An Coimisiún Pleanála,
64 Marlborough Street,
Dublin 1,
D01 V902

241164/PL/ACP1

Re: Case Number: ABP-322037-25
Request for Further Information for Proposed works at Park Road Bridge, Limerick.

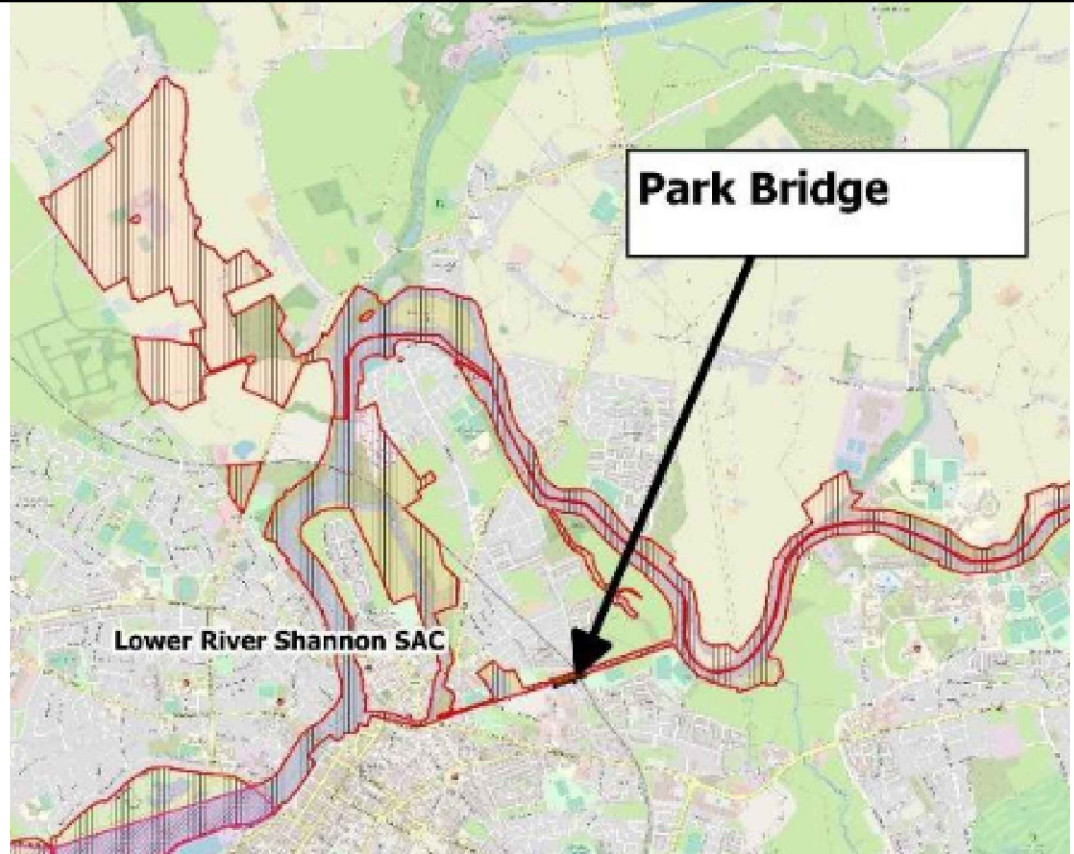
- (b) Documentation in relation to Part (ii) should include reference to the historical significance of the structure to be repaired and any other matters relating to the proper planning and sustainable development of the area which may be relevant.

[Strengthening works are required to rehabilitate this flat deck element and supporting beams of the bridge and ancillary repointing and vegetation control will be undertaken to the masonry bridge structure as shown on the proposed works drawings.](#)

[A temporary work platform would be erected at the underside of the bridge to provide access. The temporary beam currently supporting the bridge would be replaced by a permanent steel beam. The existing beams would be shot blast and repainting and the temporary decking removed. Masonry would be cleaned of vegetation and joints repointed as necessary. \(Ref: ABP 3039360-21, Inspector's Report P6\)](#)

[Note: Concrete beams proposed as alternate to replacement steel beams under current proposal.](#)

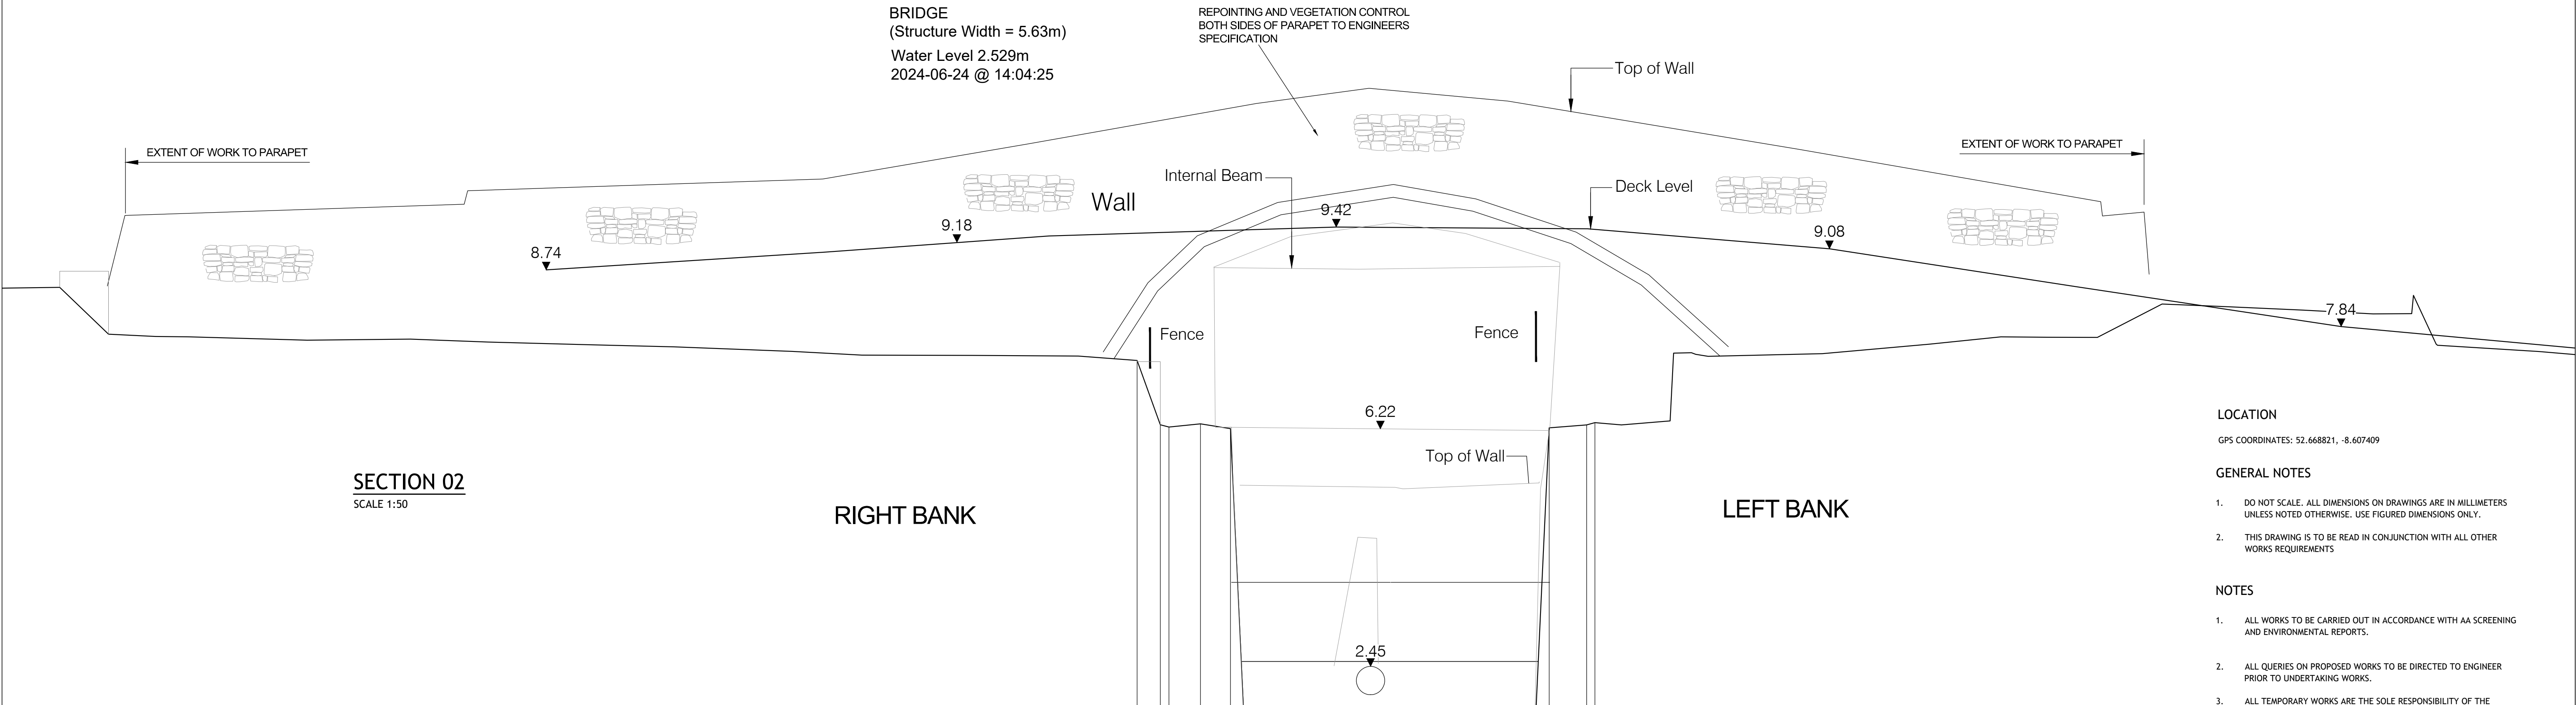
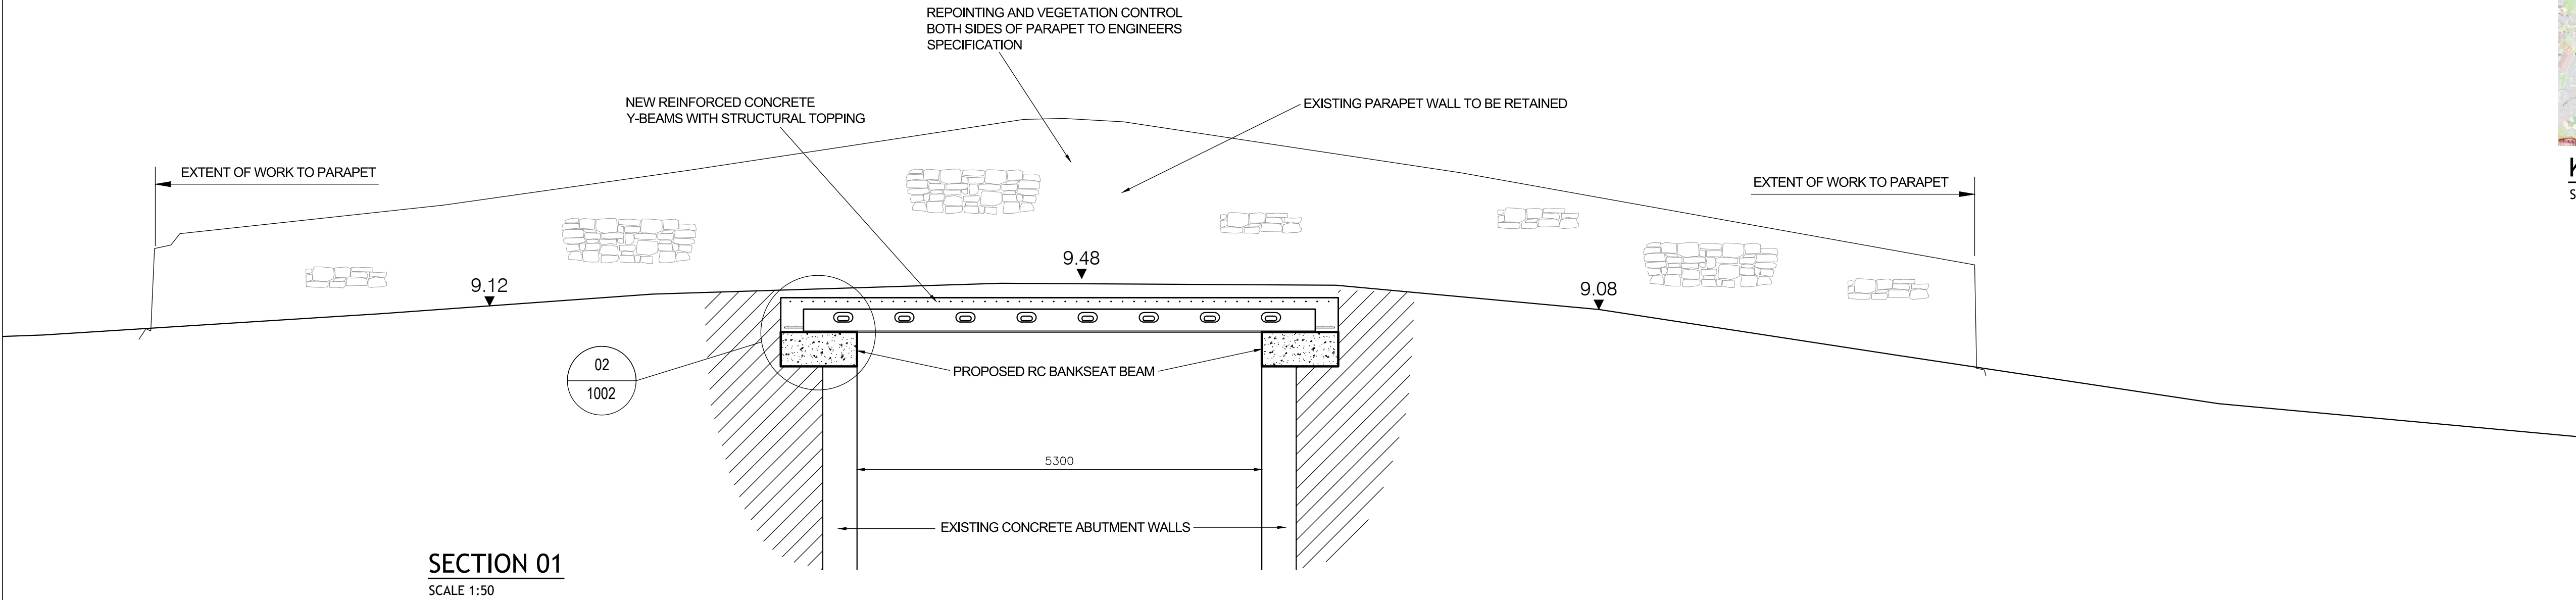
Cait ni Cheallachain, Conservation Architect

Updated drawings have addressed the concerns raised under this submission. The spandrel and parapet walls of the bridge will be repointed with NHL lime mortar in accordance with the Engineer's Specification.

Where existing cement mortar is readily removeable, it will be replaced with NHL lime mortar. In situations where its removal would damage surrounding stonework, it will be left in place so as not to adversely affect the aesthetic of the bridge further.
